Stantec Architecture Inc.
722 12th Street NW Suite 100, Washington DC 20005-3957

October 21, 2022

Reference: New Mexico Proton Advanced Cancer Therapy (NMPACT)
Response to Development Review Board Comments
Project: PR-2022-007588
Application: SI-2022-01658

LANDSCAPE - LANDSCAPE PLAN

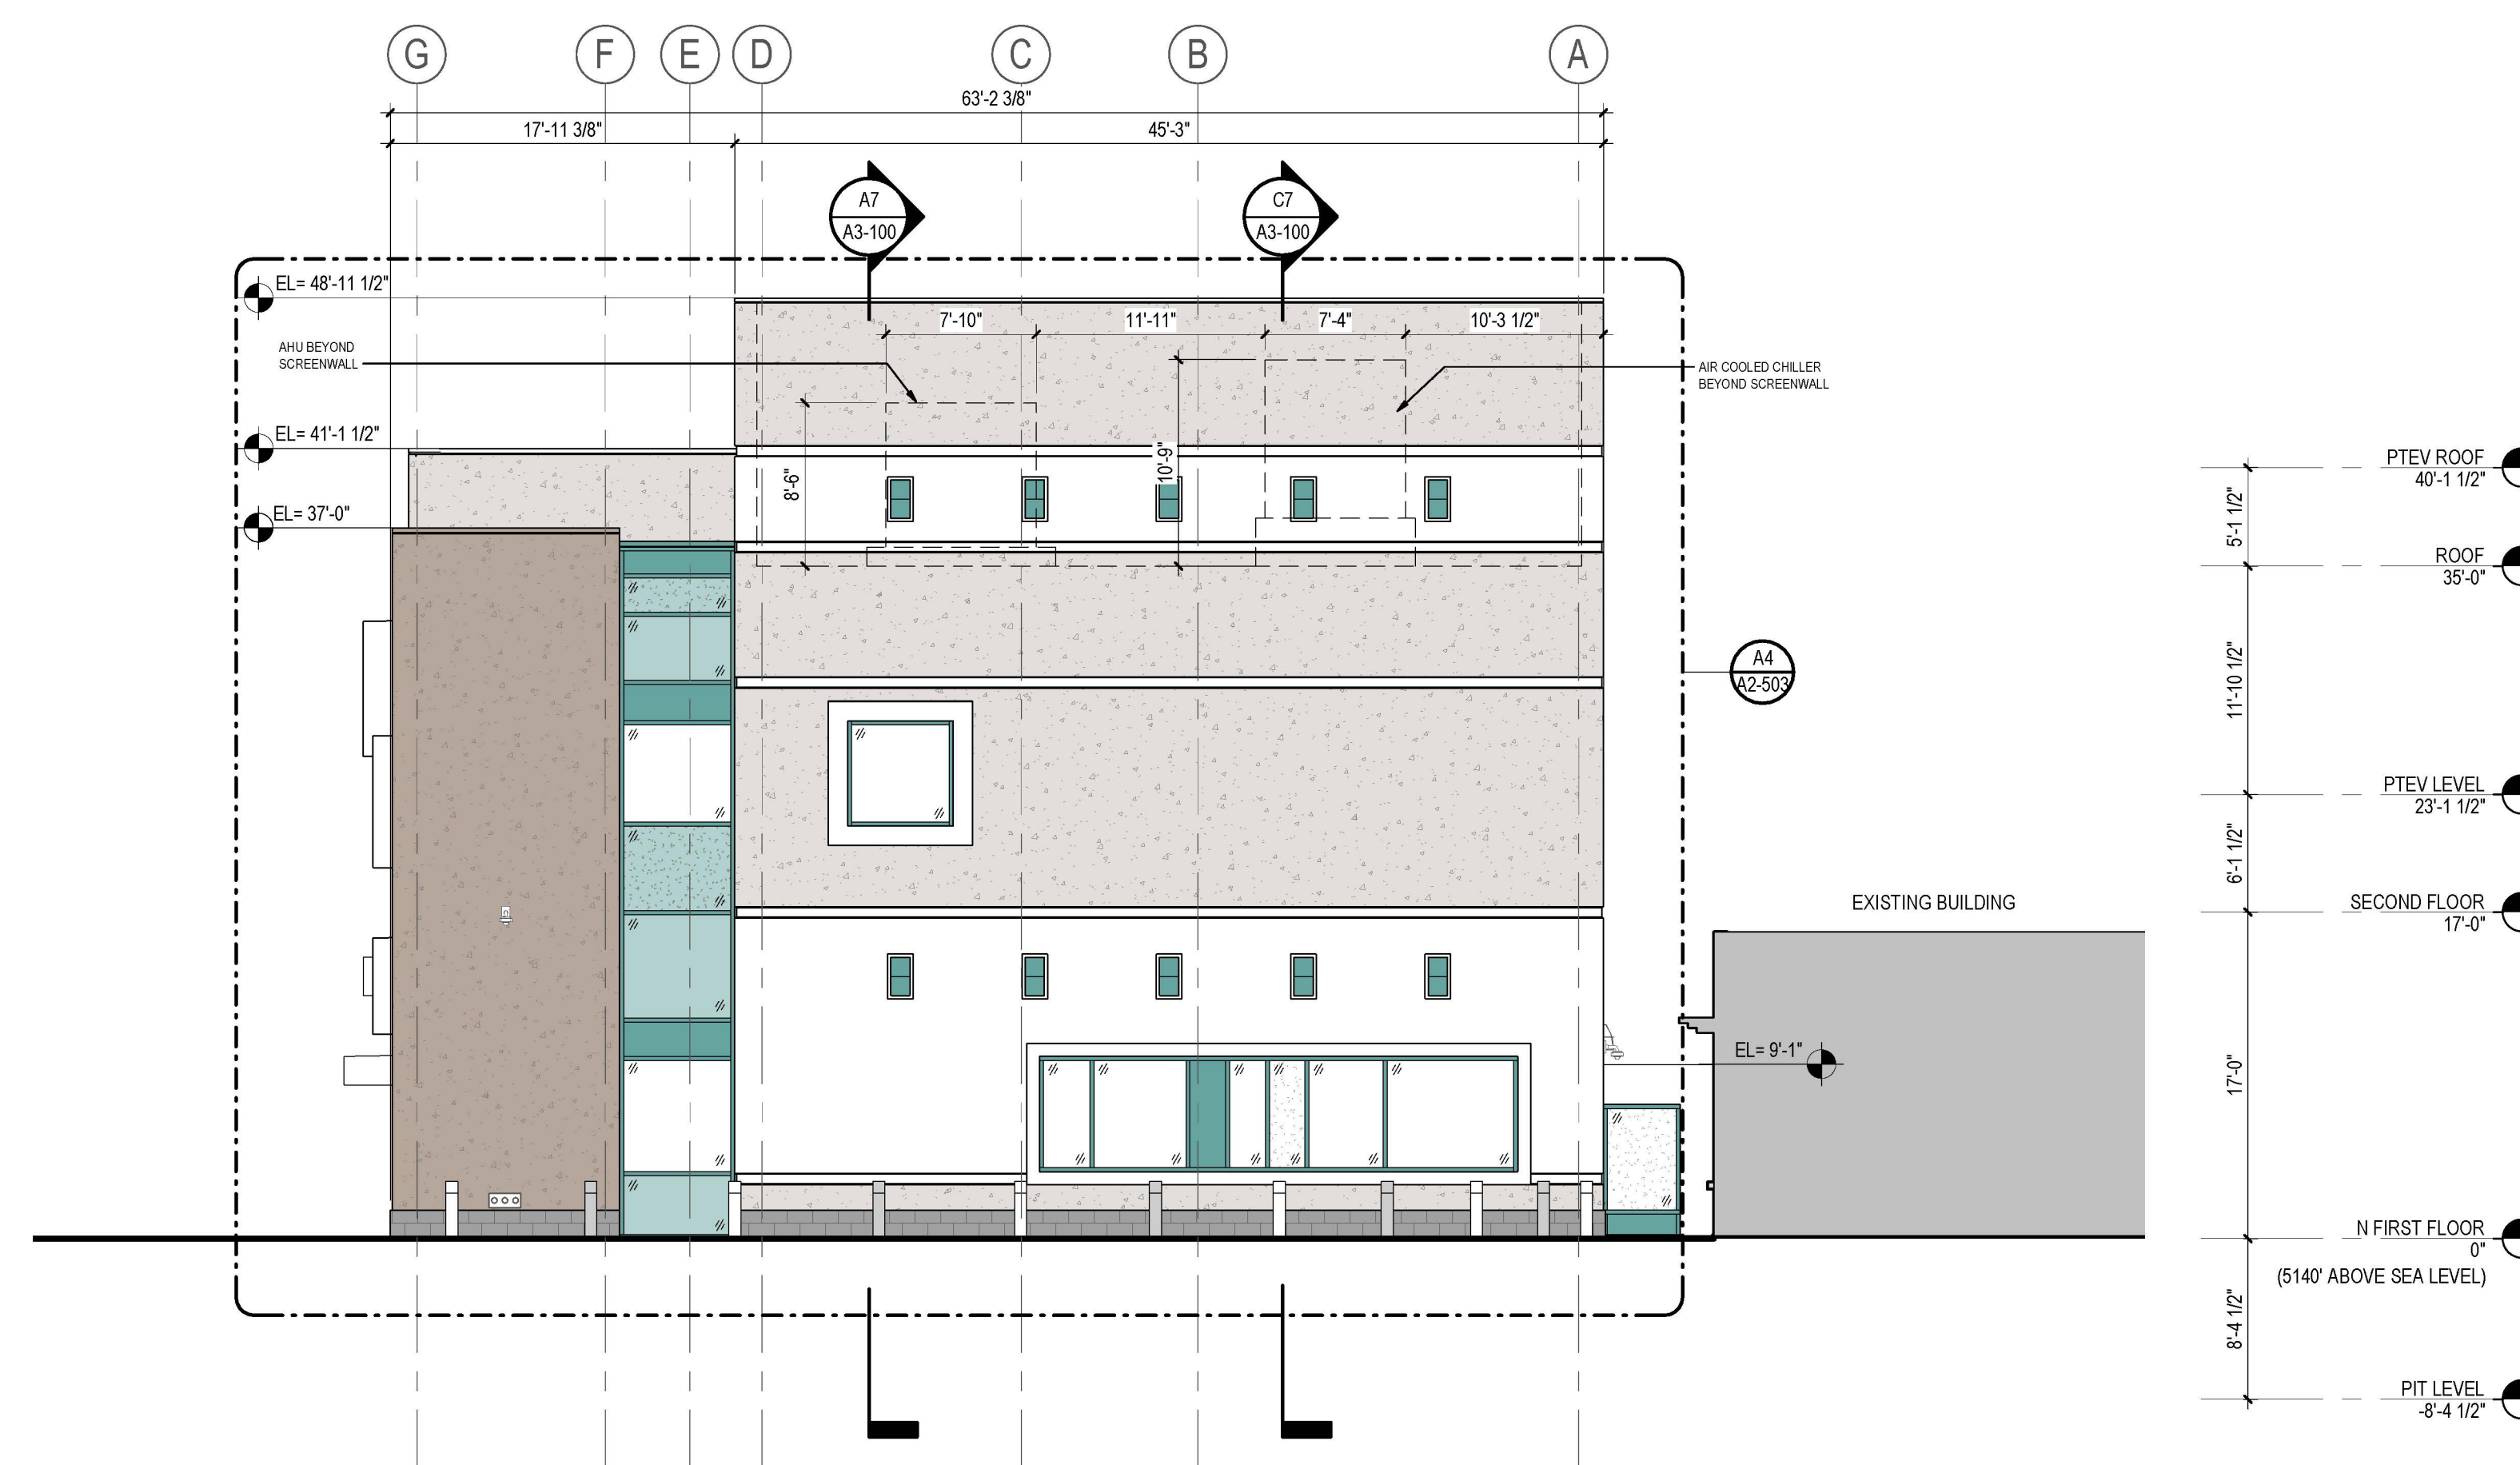
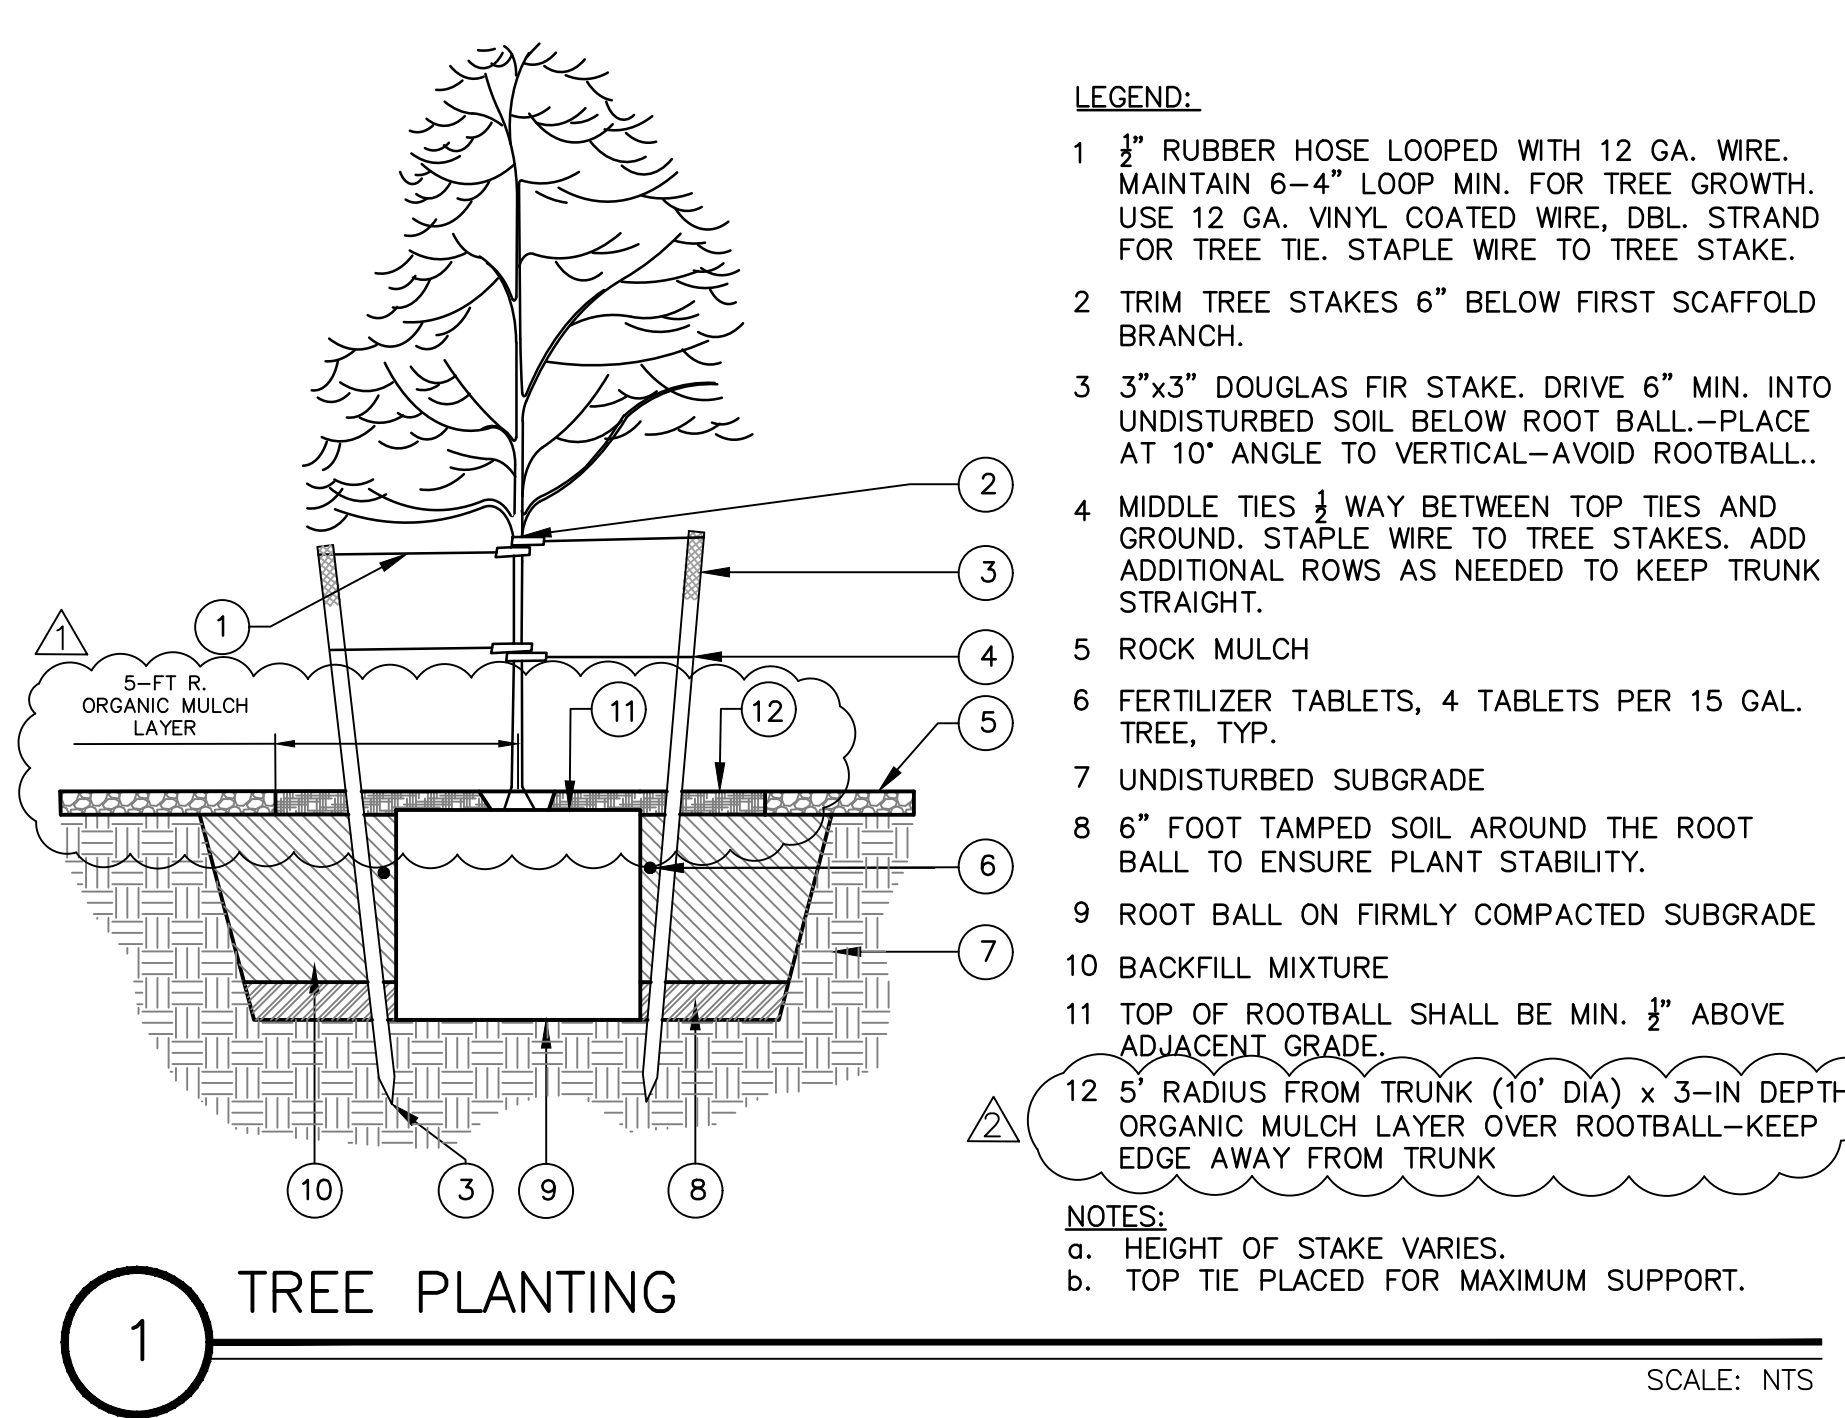
11. The Landscape Plan must meet the 15% net lot area landscaping requirement per 5-6(C)(2) of the IDOS. Confirmation and calculations of this requirement must be provided on the Landscape Plan. (The plan sheet seems to state that the fire lane makes this requirement non-applicable, however staff is not able to confirm this per the IDO.)

12. The Landscape Plan depicts the removal of two large Chinese Pistache trees from the parking area. Staff discourages the removal of mature trees from a development if there is a way to save them. Please explain and justify their removal.

- a. *Stantec Response: Noted.*
3. Landscaping must meet requirements of IDO 5-6, Landscaping, Buffering, and Screening. Provide revised calculations showing how it is meeting IDO requirements.

- a. *Stantec Response: Net lot area landscaping has been calculated for the entire site and the project exceeds the 15% minimum requirement. Sheet C-701, Landscape – Landscape Plan has been updated with the calculation. See attached.*

- a. *Stantec Response: The existing, mature Pistache trees are removed because they will be negatively impacted by construction of new fire lane improvements. In our experience they would not survive trenching and installation of new curbing because its within their critical root zone (5-10 feet of their trunks). Additionally, construction of the new parking lot will recompact the soil - creating oxygen deprivation. We propose new trees in new planter conditions as the surest approach to providing healthy plants.*

- a. *Stantec Response: Required calculations for IDO 5-6 have been added to tables on C-701 (attached). The project is in compliance with following exceptions:*

- i. 5-6(D)(2) – Additional Street Frontage – landscaping around building foundation. This is not met, and a variance is requested due to site constraints and potential impact to lost parking.
- ii. 5-6(E) – Edge Buffer Landscaping. This is not met along the southern and eastern sides of the property. The existing trees are spaced at wider intervals and a variance is requested due to budget.
- iii. 5-6(F) Parking Lot Landscaping. This is met for new improvements but is not met for existing. Existing lots have it about 200' (versus 100' requirement). A variance is requested due to budget.
